DECISION DELEGATED TO HEAD OF PLANNING

Application No: H06-0299-24 **Applicant:** Mr O Read

Proposal: Details of landscaping & tree planting, site & floor levels, contamination of land or pollution of controlled waters, boundary treatments, foul and surface water disposal (Conditions 4, 5, 6, 11 & 15 of H06-0848-23)

Location: Land Adjacent To Sea Breeze Marsh Road Gedney Drove End

1.80M CLOSE BOARDED FENCING DETAIL

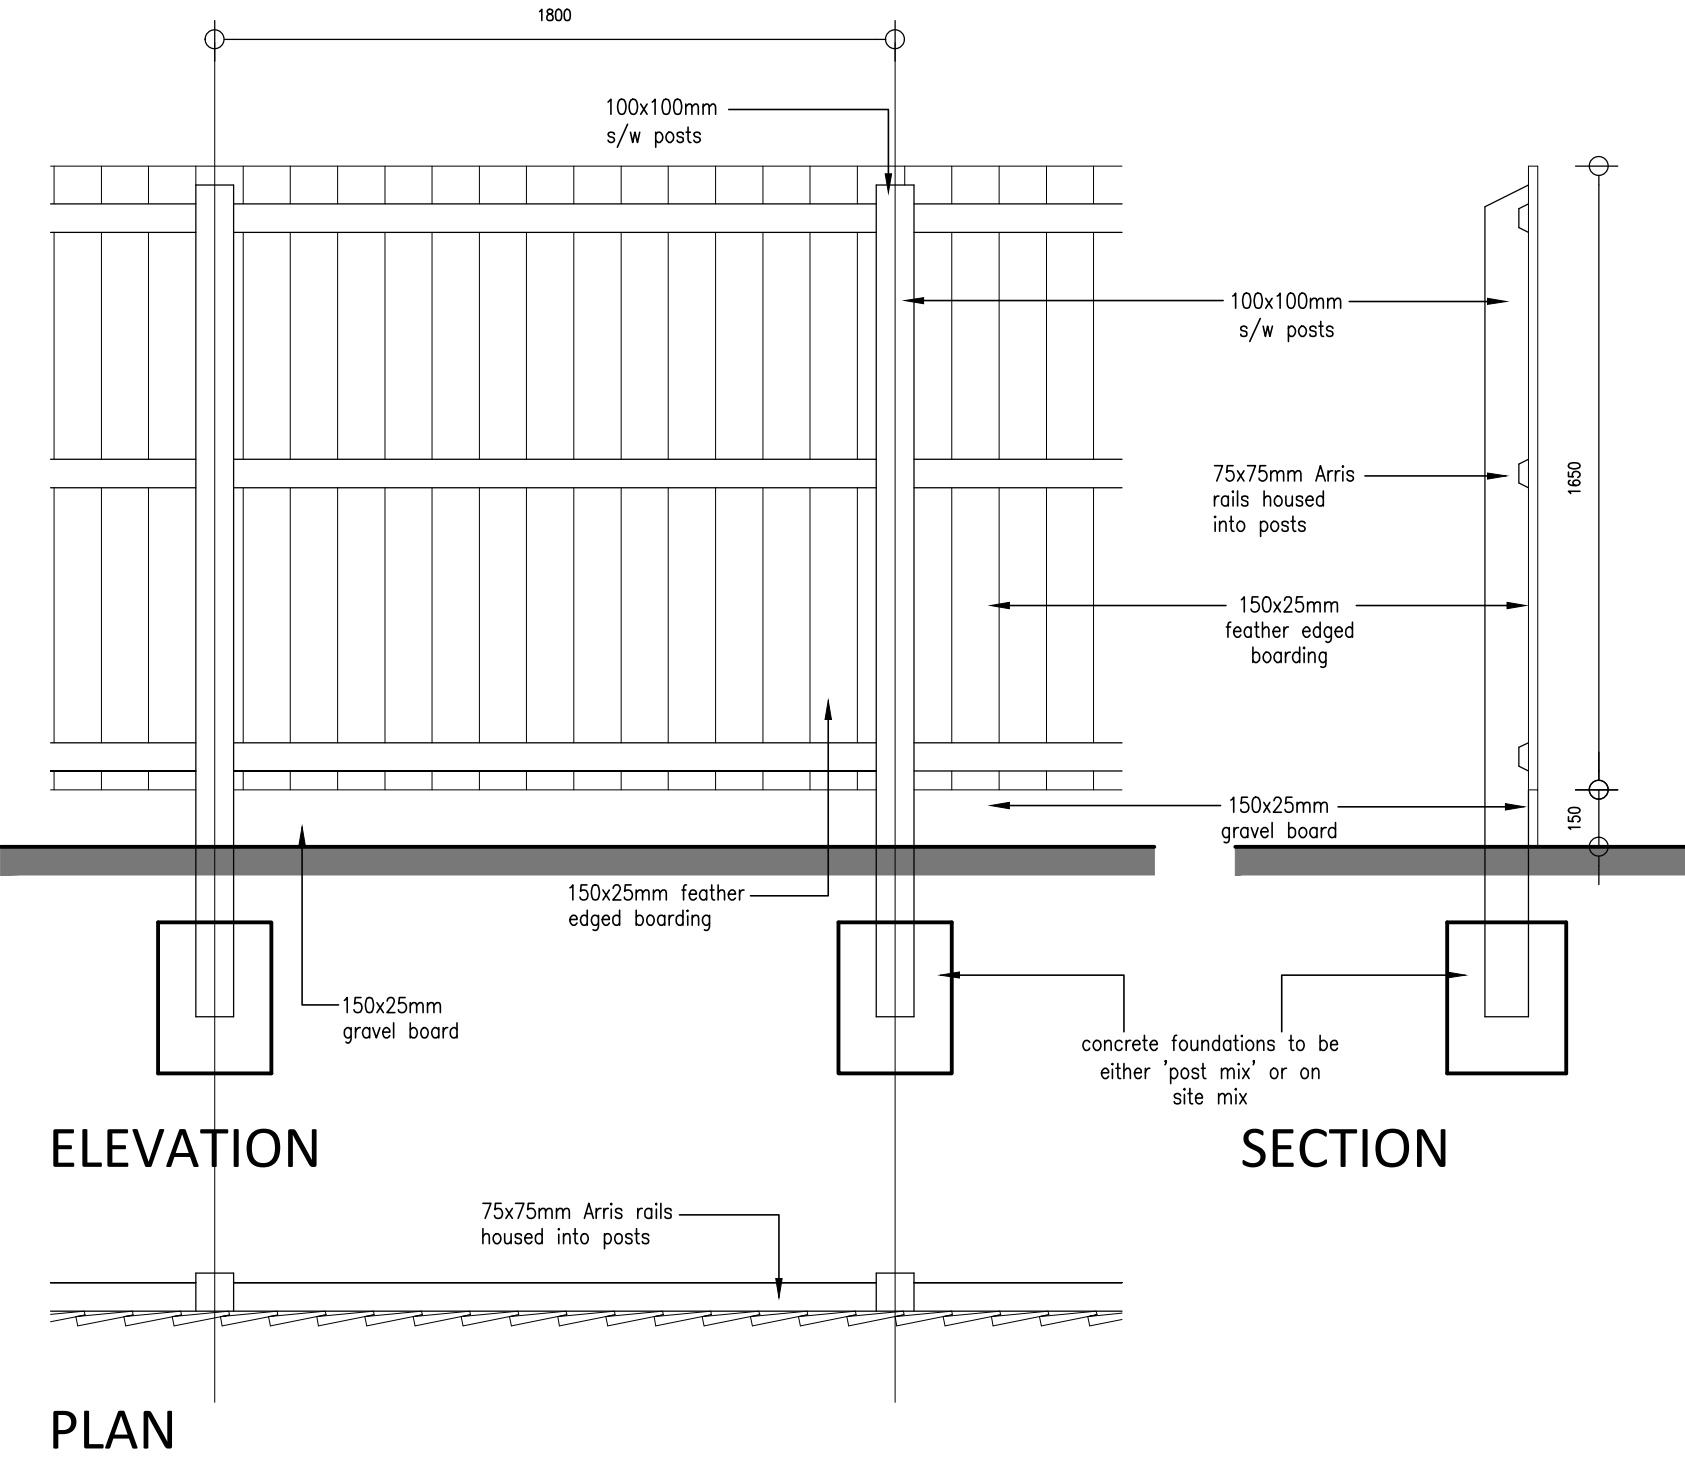
From the plan labelled '6797/C02' it shows there are two fence designs and a separate gate. On both side elevations there is a 1.8m close boarded fence with a 1.2m close boarded fence running across the north western elevation of the rear curtilage. Directly adjacent to the rear fence there shall be a hedge connecting to the side fence, furthermore directly opposite this there shall also be a hedge being of a similar length. These boundary treatments are considered to provide adequate privacy for the residents of this property once constructed as well as providing cover for neighbouring plots. There shall be no overshadowing or overbearing issues either.

South Holland Internal Drainage Board were consulted on this application, through this process they raised no objections. Consent may be required under Byelaw 3, it is not currently required for Section 23 and is not applicable to Byelaw 10. From 6797/C02 it shows that there is a crated soakaway within the private garden for surface water drainage, it is to be positioned a minimum of 5m from buildings and boundaries. Furthermore, there shall be a cesspool below this for foul water drainage with the tank to be a minimum of 7m from buildings.

Byelaw 3 (Surface Water) - The applicant has indicated that they intend to dispose of surface water via infiltration, however I cannot see that the viability of this proposal has been evidenced. We recommend that ground investigation is carried out to determine infiltration potential, followed by testing in line with BRE Digest 365 if onsite material is considered favourable for infiltration. If infiltration is not feasible at this site, following the drainage hierarchy we would expect the applicant to propose to discharge surface water to a watercourse. In this case, consent would be required under Byelaw 3. Please note that we recommend that any discharge is in line with the Non-Statutory technical standards for sustainable drainage systems (SuDS), therefore the Board is unlikely to grant consent for discharges in excess of greenfield rate. A surface water development contribution is likely to be payable as a condition of any consent granted under Byelaw 3 in line with the WMA's Development Control Charges and Fees.

Byelaw 3 (Treated Foul Water) - I note that the applicant intends to contain foul water using a cesspool, which would then be disposed of off-site. However, please be advised that should there be a discharge of treated foul water to a watercourse, consent would be required under Byelaw 3.

Condition 11 of H06-0848-23 can therefore be discharged.

Condition 15 of H06-848-23 can therefore be discharged.
